Submission No.			24	
Organisation Name or Name of Submitter			Bovale ULC and Balheary Properties ULC (represented by ILTP Consulting)	
Item No.	Section Ref.	Page No.	Observation Statement	TII Response
<b>RE: Submission on Behalf of Bovale ULC and Balheary Properties ULC on Proposed Scheme and CPO (Compulsory Purchase Order) of Lands</b>				
1	Letter	1	<p>The scheme as currently submitted to An Bord Pleanála (ABP) would, if approved, mean that with the temporary and permanent land-takes proposed, little if any development could, in reality, take place on the adjacent retained lands until after the Metro is complete.</p> <p>The development of the lands immediately adjacent to major high capacity public transport should ideally take place in advance and in tandem with the proposed scheme as this would maximise the patronage of the Metrolink and hence its economic viability. Bringing forward lands for development in tandem with the Metrolink also accords with good planning practice.</p> <p>The lands are currently zoned as <b><i>“ME - Metro Economic Corridor - Facilitate opportunities for high density mixed use employment generating activity and commercial development, and support the p

ESTUARY STATION - PLATFORM LEVEL PLAN

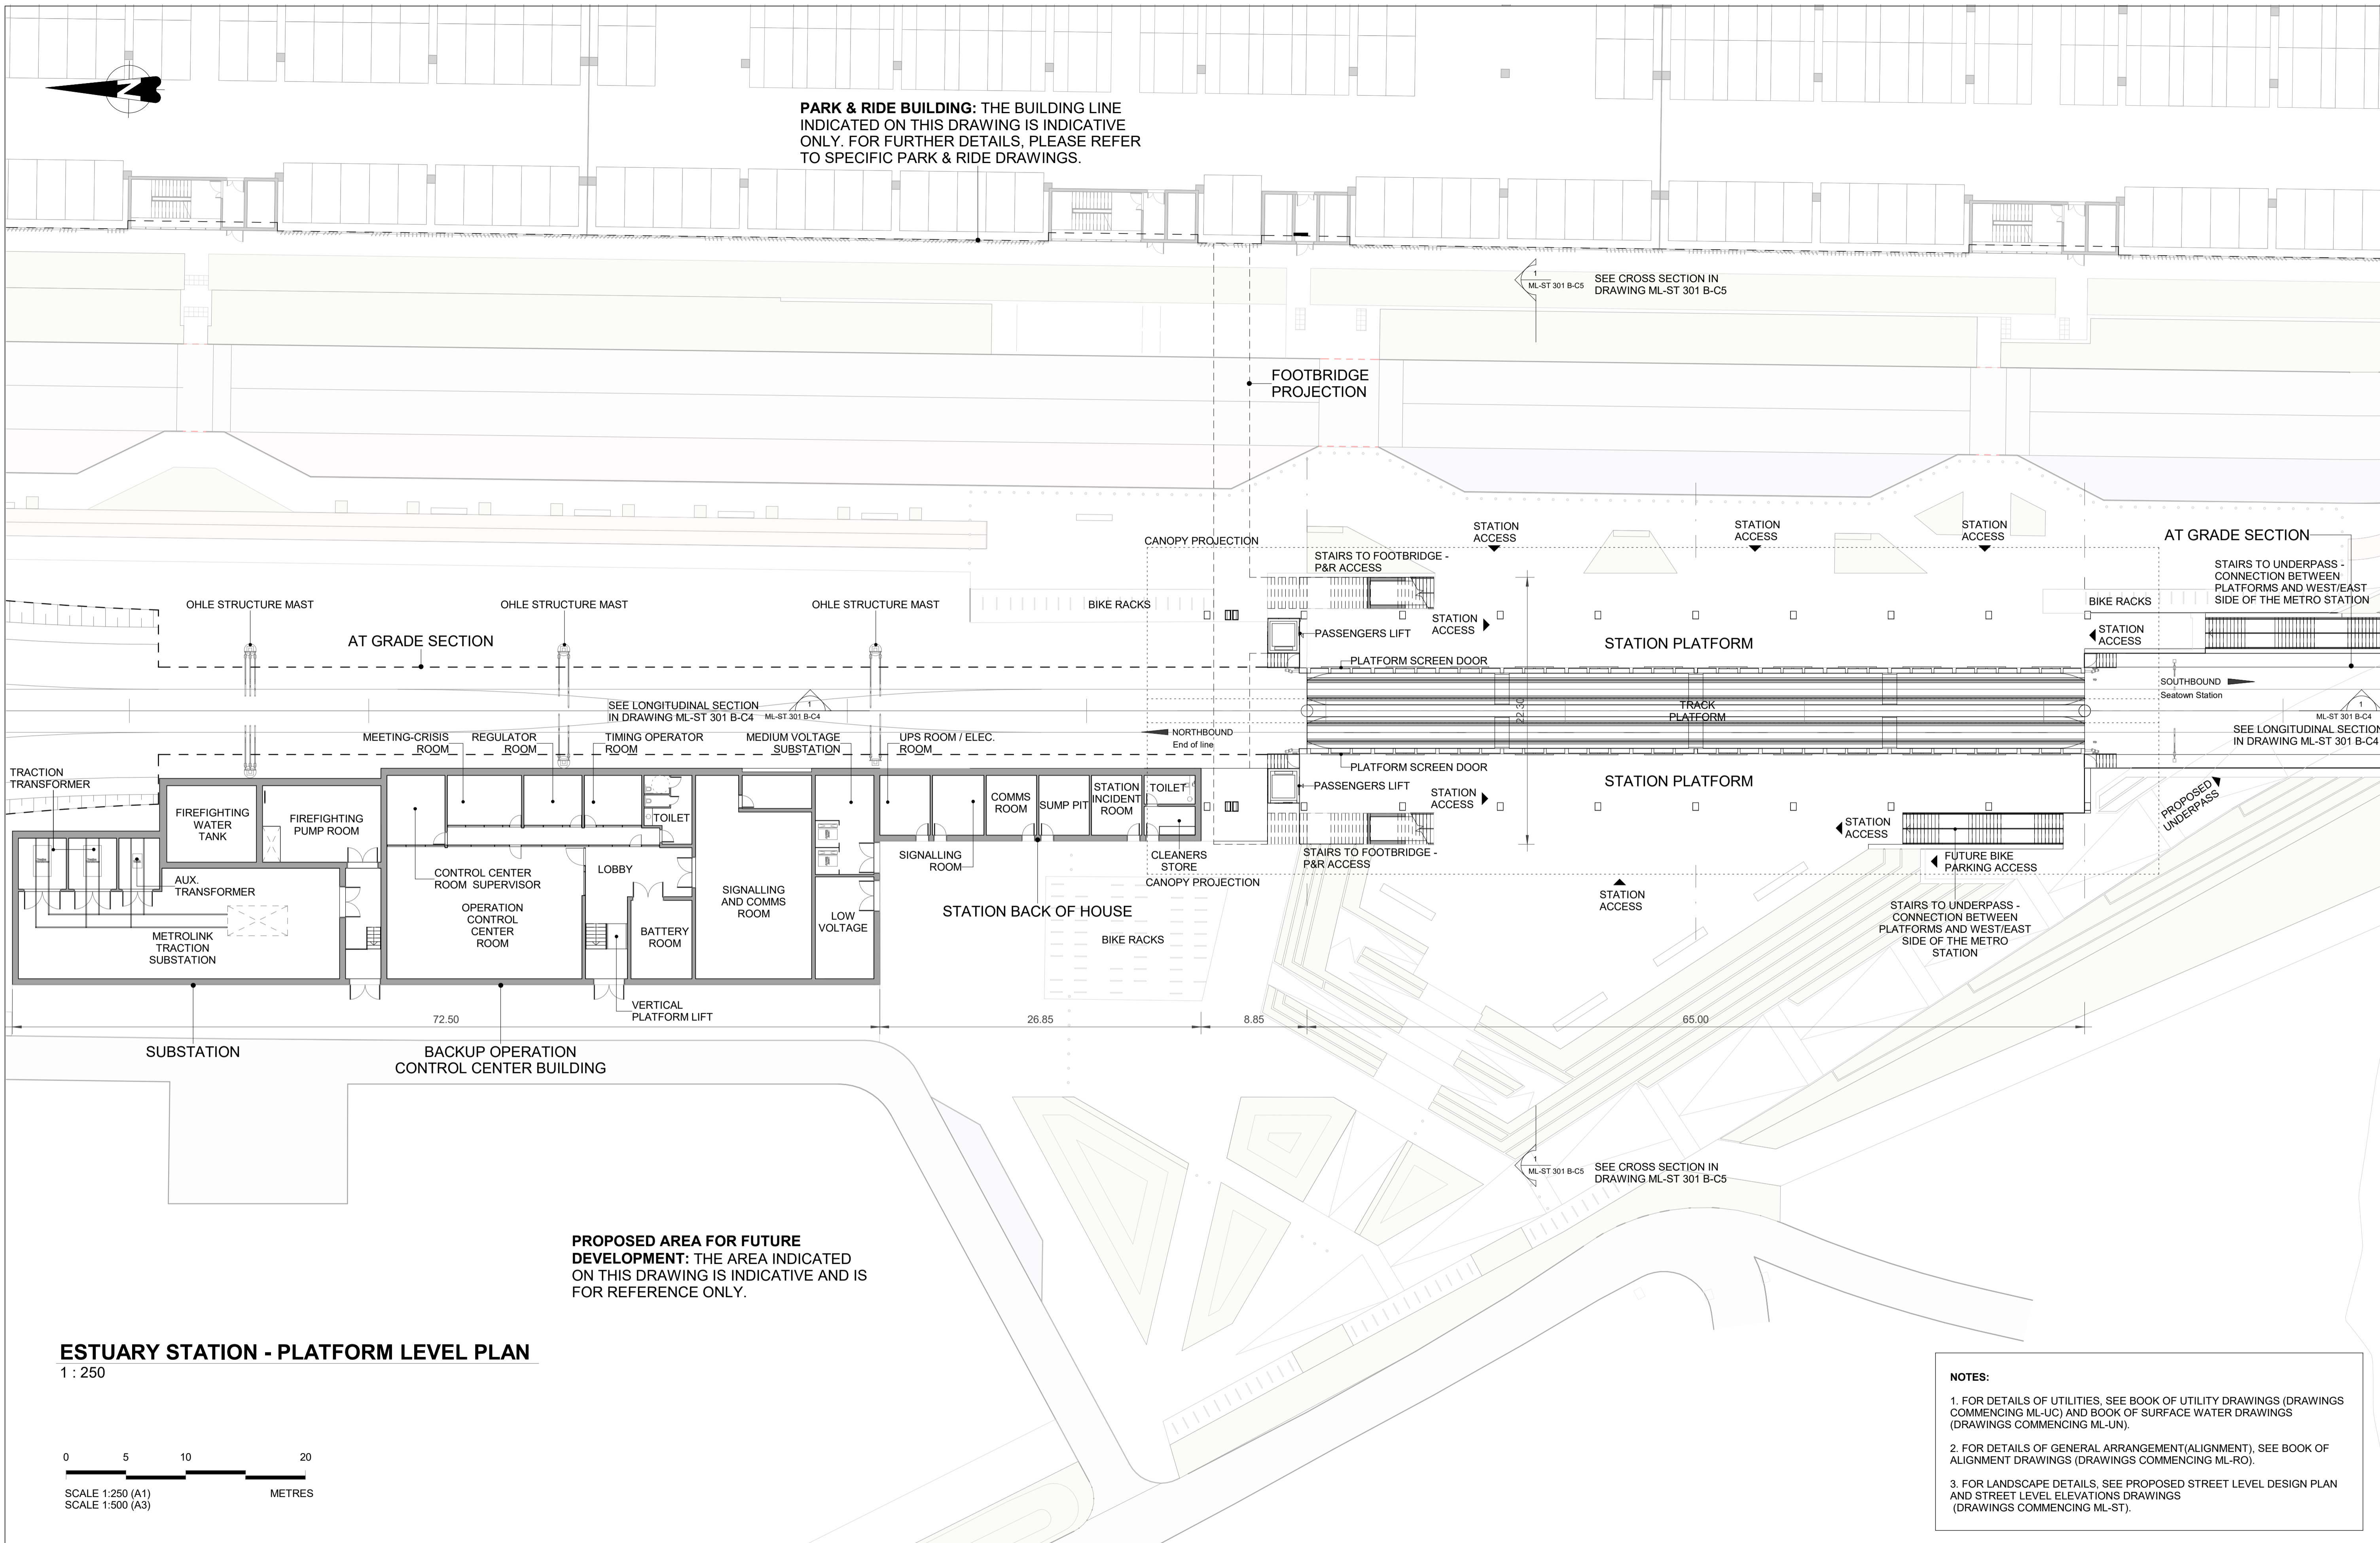
2	Letter	1	<p>Figure A attached shows proposed modifications to the Metrolink scheme, which if approved by ABP would allow for the integrated development of the retained lands with the proposed Metrolink scheme. This in turn would allow for the orderly and timely delivery of appropriately development on the adjacent lands. The main changes proposed include:</p> <ul style="list-style-type: none"> <li>• Allowing for the delivery of access via the Swords Western Distributor Road off the R132 to the retained lands that would facilitate appropriate development on the retained lands.</li> <li>• Improved linkages (or provision for same) between the proposed Lissenhall stop and the retained lands.</li> <li>• There are two areas of land included in the CPO which do not appear to be necessary or required for the proposed scheme. Our client wishes to retain control over these lands.</li> </ul>	<p>Regards bullet points 1) and 2), TII would note that they have provided infrastructure to facilitate the Park &amp; Ride at this location. The amendments proposed by this submission extend beyond the scope of the MetroLink Project and the remit of TII. The additional accesses and road linkage proposed therefore would need to form a separate planning application by Bovale ULC and Balheary Properties ULC and would need to be agreed with FCC. TII have had a number of meetings with Bovale ULC and Balheary Properties ULC and have expressed our support for such works to be carried out by the developer subject to those works being in accordance with proper planning and sustainable development and in compliance with the policies and objectives of Fingal County Council.</p> <p>Further consultations with the developer in relation to these proposals are required in order to ensure any access provision or modification does not compromise the construction of MetroLink Infrastructure or the operation and maintenance of the MetroLink Station, Park &amp; Ride and Railway Infrastructure generally.</p> <p>Regards bullet point 3), the areas of land referred to, as outlined in EIAR Chapters 5 (MetroLink Construction Phase) and 21 (Land Take), are required for a construction compound and logistics site to enable the construction of Estuary Station.</p>
